**re: Geotechnical Review**  
**Proposed Hotel Building**  
**300 Moodie Drive - Ottawa**

**to:** Colonnade Bridgeport - **Ms. Bonnie Chen** - bchen@colonnadebridgeport.ca  
**to:** Novatech - **Mr. Francois Thauvette** - f.thauvette@novatech-eng.com  
**to:** SiteCast - **Mr. Shawn Hickey** - shickey@sitecast.ca  
**date:** April 16, 2018  
**file:** PG4148-MEMO.01

LOCATION CITY OF OTTAWA 300 MOODIE DRIVE		PROJECT No.	118007
DRAWING NAME GENERAL PLAN OF SERVICES		REV	REV # 5
		DRAWING No.	118007-GP

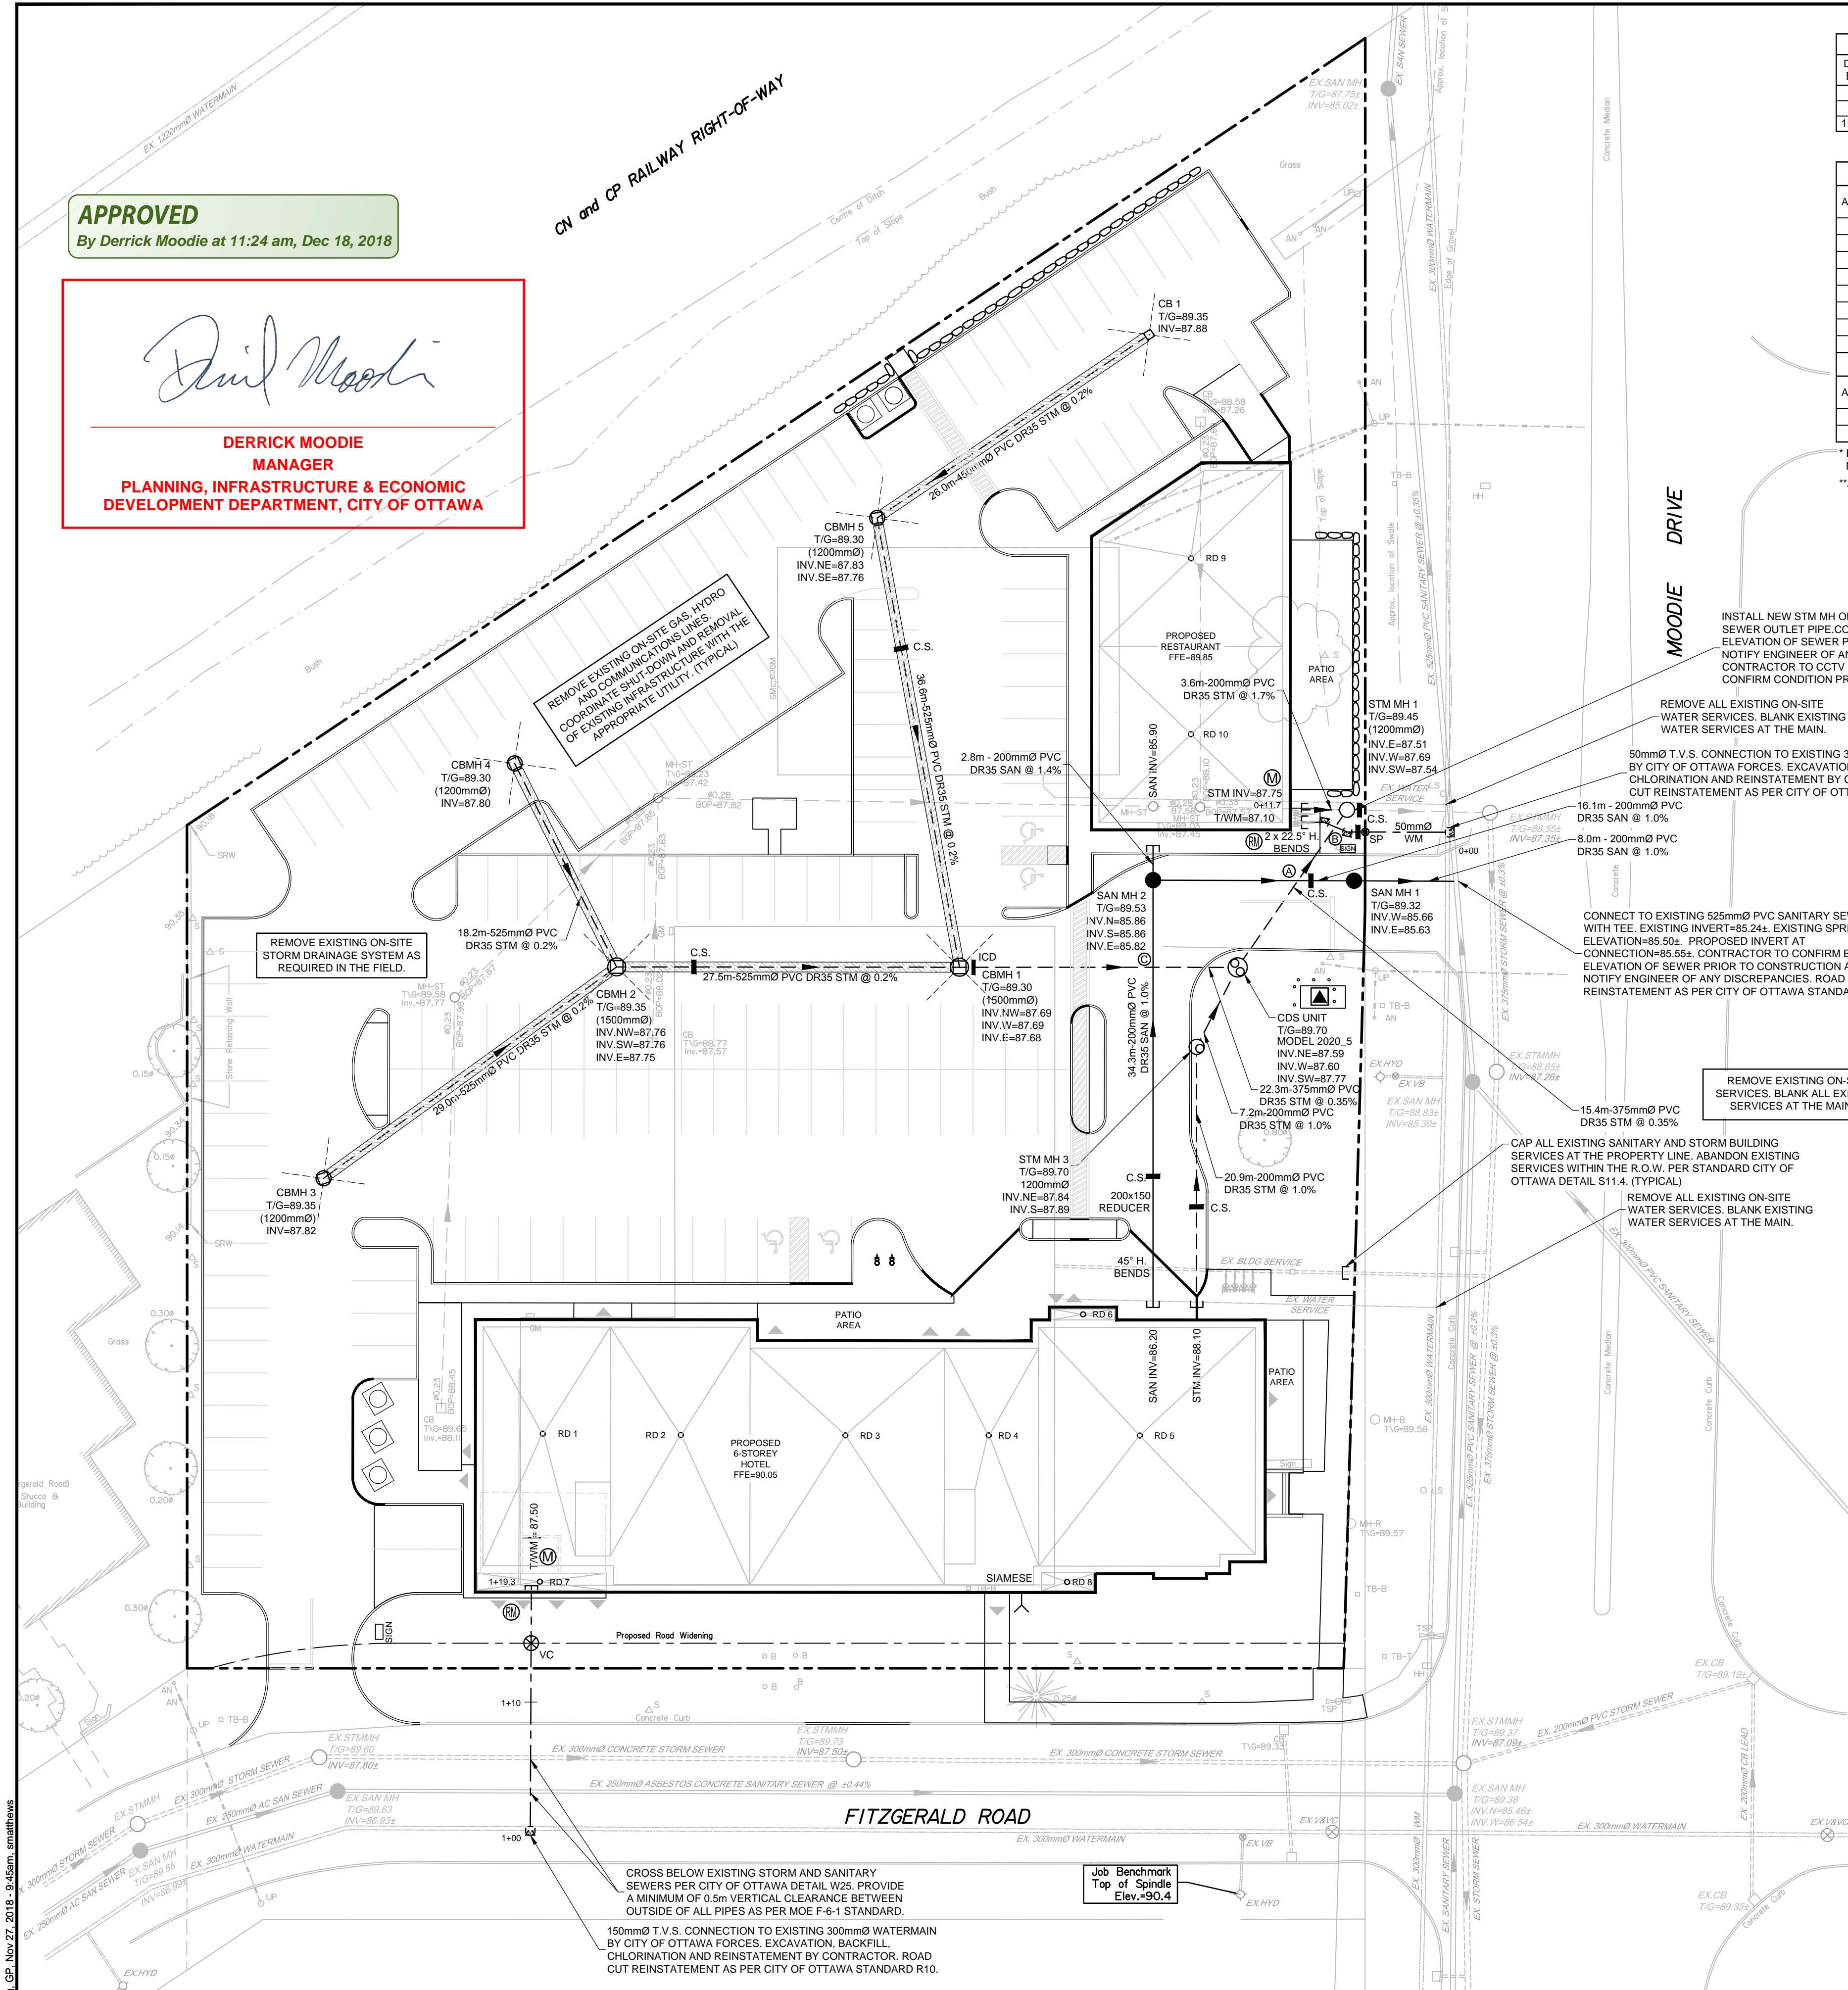
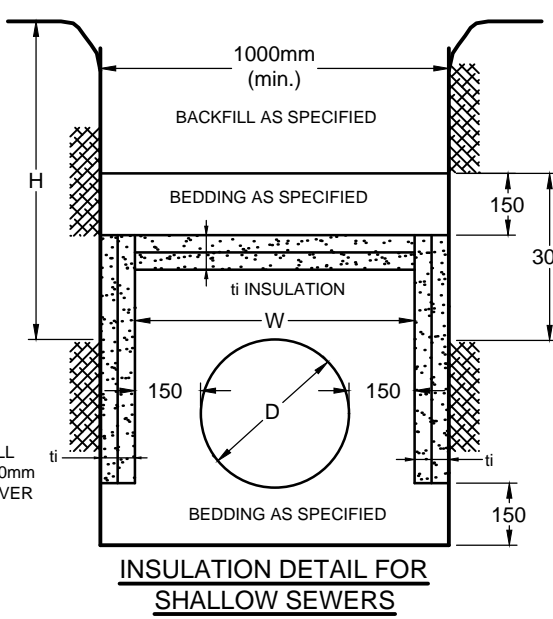
## Insulation Detail for Storm Sewer Pipes

Paterson has reviewed the proposed grading and site servicing plans for the aforementioned site. Based on these details, sections of the storm sewer will be provided with approximately 1.5 m of soil cover which is less than 2.1 m. Therefore, insulation of shallow storm sewer pipes should be insulated as per City of Ottawa Standard W22. SM rigid insulation is acceptable for use to insulate the sewer pipes. This standard has been attached to the present memo.
